## Engineers Comments Regarding Surface Water Drainage

| <b>Application Reference:</b>   | BE/141/25/DOC                                                                                                                 | <b>Reviewer Reference:</b> | ADC/EXT4b  |
| <b>Site Name:</b>               | Land at Oldlands Farm Newlands Road Bognor Regis PO22 9NN                                                                     |                            |            |
| <b>Application Description:</b> | Approval of details reserved by condition imposed under BE/150/22/OUT relating to condition 22-surface water drainage scheme. |                            |            |

243912-BWB-EXT-XX-D-C-0500-[A5-C07]_Drainage Layout

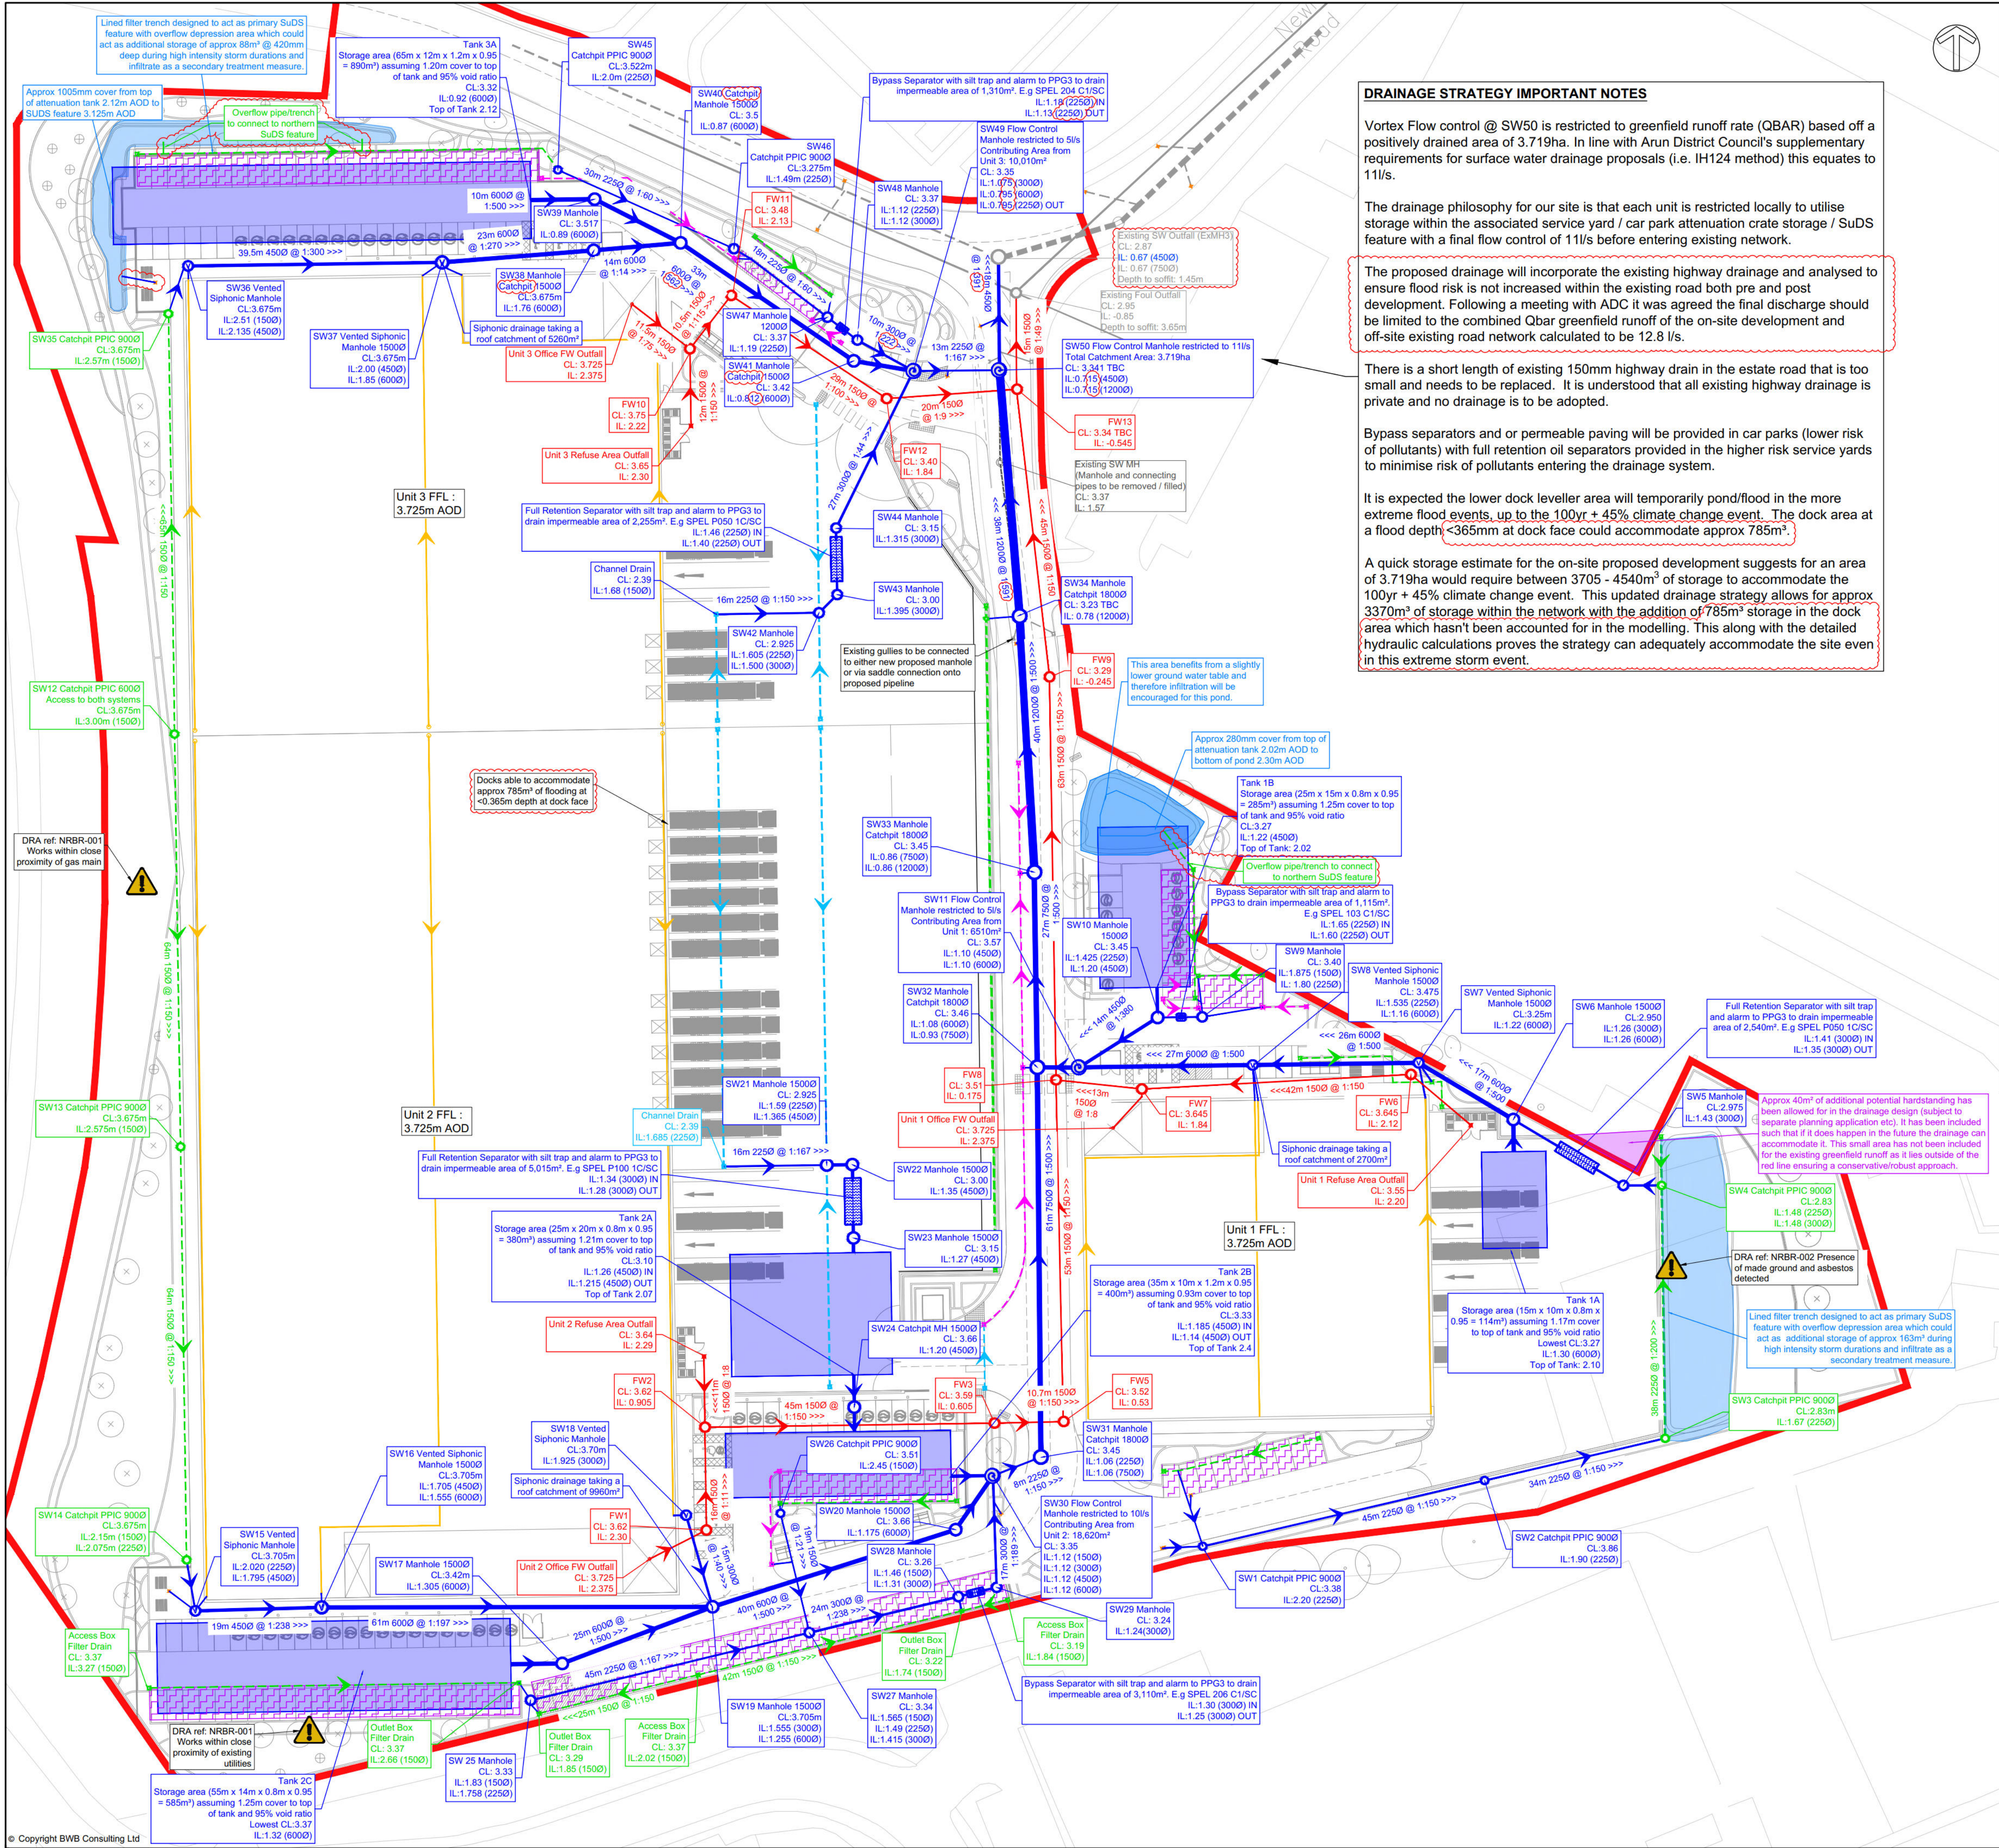
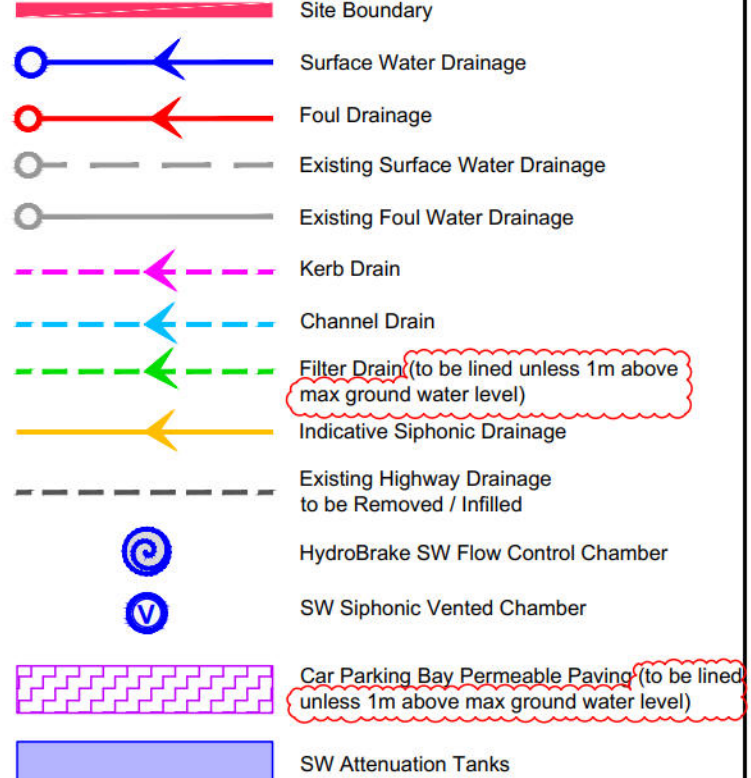
| 12. | <p>The network floods on the critical 3.33% AEP event (both onsite and offsite). This is unacceptable. Please redesign so that the system does not flood for this event.</p> | <p>On-site within the red line boundary the drainage strategy demonstrates that there is no flooding within the 3.33% AEP event (refer to results 243912-BWB-EXT-XX-T-0500-[A4-C08] page 20-22).</p>                                                                                                                                                                                                                                                                                                                                                                                                                                                                                                                                                                                                                                                                                                                                                                                                                                                                                                                                                                                                                                                                                                                                                                                                                                                                                                                                                                                                                                                                                                                                                                                                                                                               |  |  |  |

|     | <p>It is not agreed that the loading docks are designated to hold or convey water as part of the design. The docks are clearly shown as holding a flooded volume within the network model.</p> | <p>In the 3.33% AEP plus additional 40% for climate change the results, based on the overall lower outfall rate of 12.8 l/s, shows minor controlled flooding in the lowest dock area. We have demonstrated on drawing 24391-BWB-EXT-XX-D-C-0538-[S2-P03] that this area would be fully operational in the 30yr + 40% event and not put any property or people at risk. This is considered acceptable both from a flood risk and operational perspective.</p> <p>With regards to the off-site/existing drainage, as highlighted in our response to comment 6, outlined previously and shown on drawings 24391-BWB-EXT-XX-D-C-0535-[S2-P03] &amp; 0538-[S2-P03] the proposed drainage significantly improves the theoretical existing offsite flooding. As the proposed drainage strategy reduces an existing flood risk issue the off-site drainage is therefore also acceptable.</p>                                                                                                                                                                                                                                                                                                                                                                                                                                                                                                                                                                                                                                                                                                                                                                                                                                        |  |  |  |
| 13. | <p>The temporary flooding of the loading docks for the 1% AEP +CCA event may be acceptable. However, the risk and impact of the proposed flooding has not been adequately assessed.</p>        | <p>The flooding of the docks is a well understood and acceptable way to deal with extreme flood events. The docks by their very purpose are naturally lower than the surrounding areas (i.e. 1.2m below FFL). To ensure they are adequately drained there is a channel drain approx. 8m from the building face. This is the lowest point of the drainage system so inevitably is the first area for water to back up in extreme events. Water will back up vertically from the channel at this low point, so there is no/minimal velocity involved.</p> <p>Panattoni is a major developer of industrial and distribution units delivering buildings for logistics operators all over Europe. They, better than anyone, understand the operation of a loading dock required by their customers. In this area of the site, vehicles reverse into the dock and are rear loaded from level access doors that are set at floor level, consistent with the level of the trailer bed. There is no side loading in the docks, this takes place at a higher elevation through the level access doors. There is no regular requirement for foot traffic or anything other than high wheelbase HGVs to access the area of the docks. As such, the operation of the loading docks is uninhibited by flooding in the extreme event.</p> <p>The Panattoni development specification accepts flooding of the loading docks in all events greater than the current 3.33% AEP to be 'designed in' to the system. This provides a balance of issues, including the drainage system functionality, the visual impact issues influenced by the finished floor level, sustainability and carbon impacts caused by excessive fill imports and</p> |  |  |  |

243912-BWB-EXT-XX-G-C-0535-[S2-P03]_Existing Downstream Highway Drainage
System Assessment

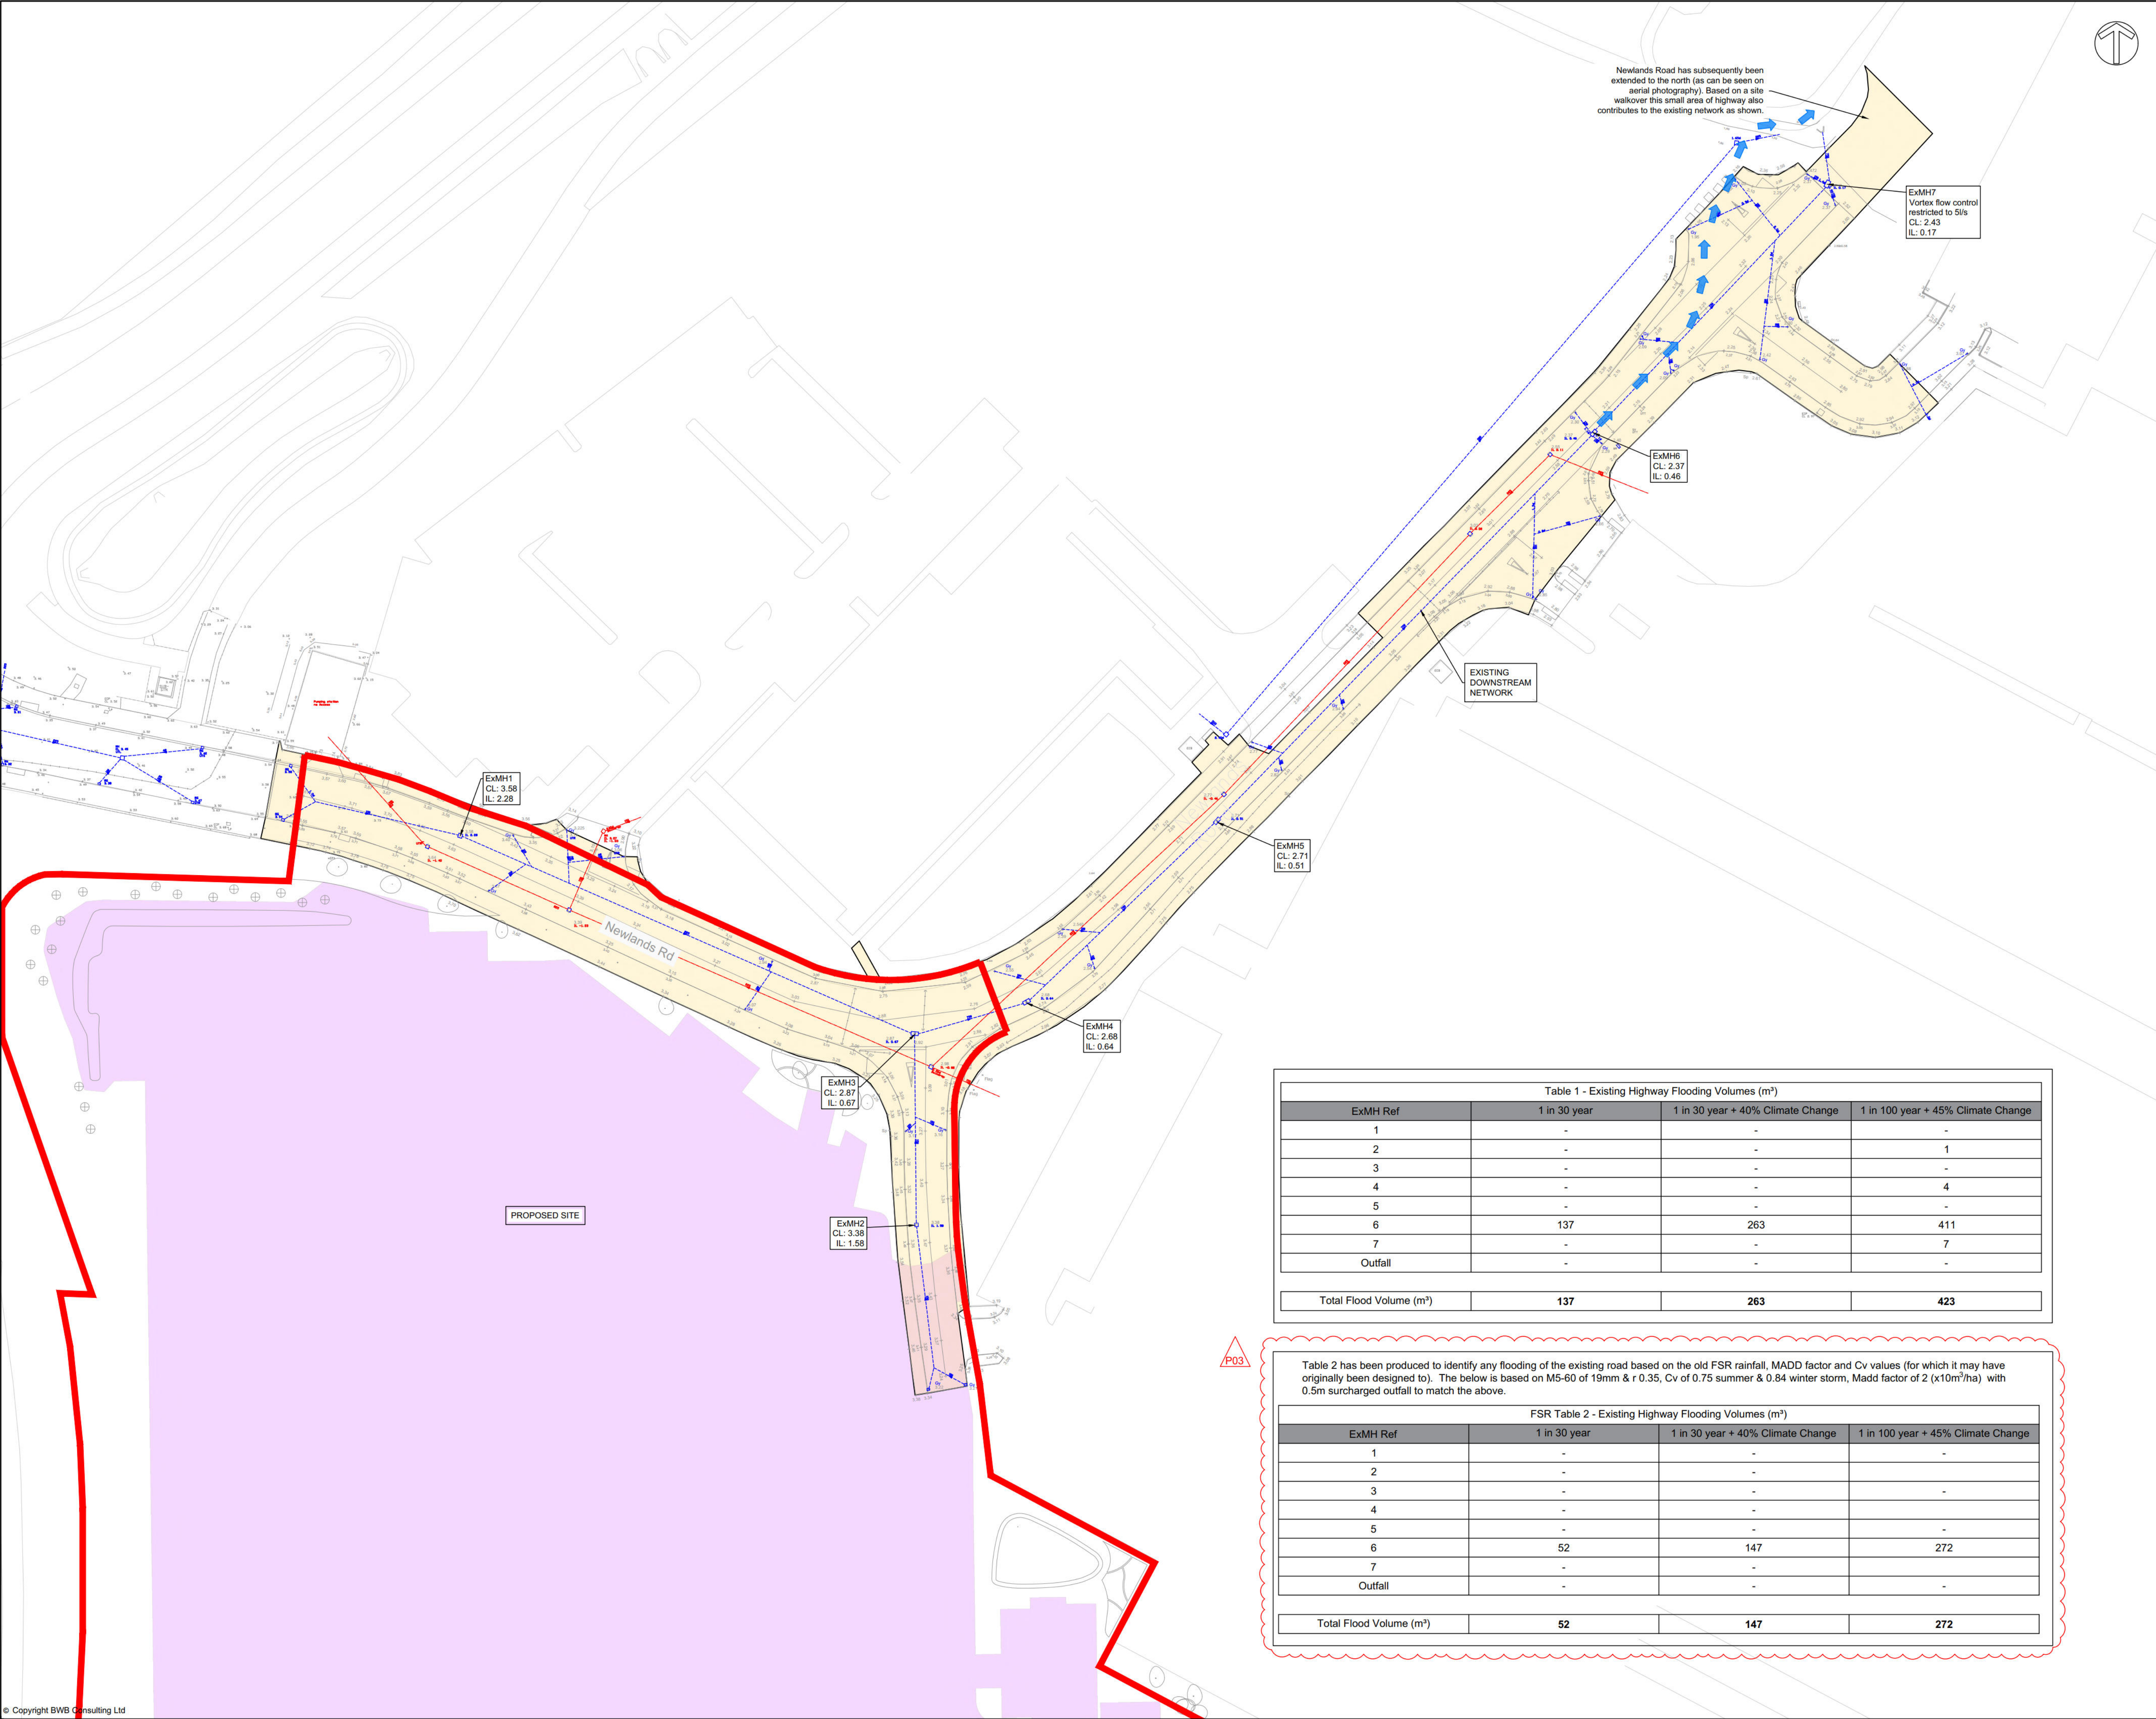
| 4. | <p>No survey data for the existing highway network has been submitted. The condition of the network and the size of manholes have not been demonstrated.</p> | <p>The existing network is part of Newlands Road which was constructed relatively recently (around 2014-15), so the surface water sewer is early in its design life. No concerns have been raised regarding the condition or operation of this existing network, given the above it is reasonable to assume the drainage is in good condition.</p>                                                                                                                                                      |  |  |  |

| 6. | <p>Existing highway is modelled to flood 263.4803m<sup>3</sup> at node 6 on the critical 3.33% AEP + CCA event. This demonstrates that without adjustments to the existing network (with an increase in discharge rate at the outfall), the existing network does not have spare capacity for the additional flow generated by this development.</p>                                                          | <p>The existing highway network comprises a 750mm surface water sewer. Based on the Colebrook white equation a 750mm SW sewer full bore at minimum self-cleansing velocity of 1m/s (1:750) can accommodate approx. 450 l/s. Our development on-site needs 11 l/s which is less than 2.5% of the pipe's capacity. Capacity is therefore not the issue, the existing flooding is a result of a volumetric issue not a conveyance one.</p> <p>We have demonstrated through detailed hydraulic modelling that the existing network theoretically floods in the more extreme events due to the limited outfall – as you highlight in the existing 3.33% AEP (1 in 30 year) + 40% climate change event there is currently 263m<sup>3</sup> flooding (pre-development). Post-development our proposal reduces this existing theoretical flooding significantly to just 154m<sup>3</sup> in the same event, this is an improvement of 41%.</p> <p>In summary, the existing system has plenty of capacity to convey the flows. The proposed design makes a demonstrable and significant improvement to the existing flood risk with a 41% reduction in the volume of flooding caused by the connection of our system and significant additional storage through that proposed in our site.</p> |  |  |  |

|    |                                                                                                                                                                                                                                                                                                                                                                             | <p>Pipe size, invert and cover levels of the existing surface water sewer are shown on the survey information submitted – refer to BWB drawing 243912-BWB-EXT-XX-G-C-0535-[S2-P03].</p> <p>A CCTV survey will be undertaken as part of the handover by the contractor at the appropriate time to validate the condition.</p>                                                                                                                                                                                                                                                                                                                                                                                                                                                                                                                                                                                                                                               |  |  |  |
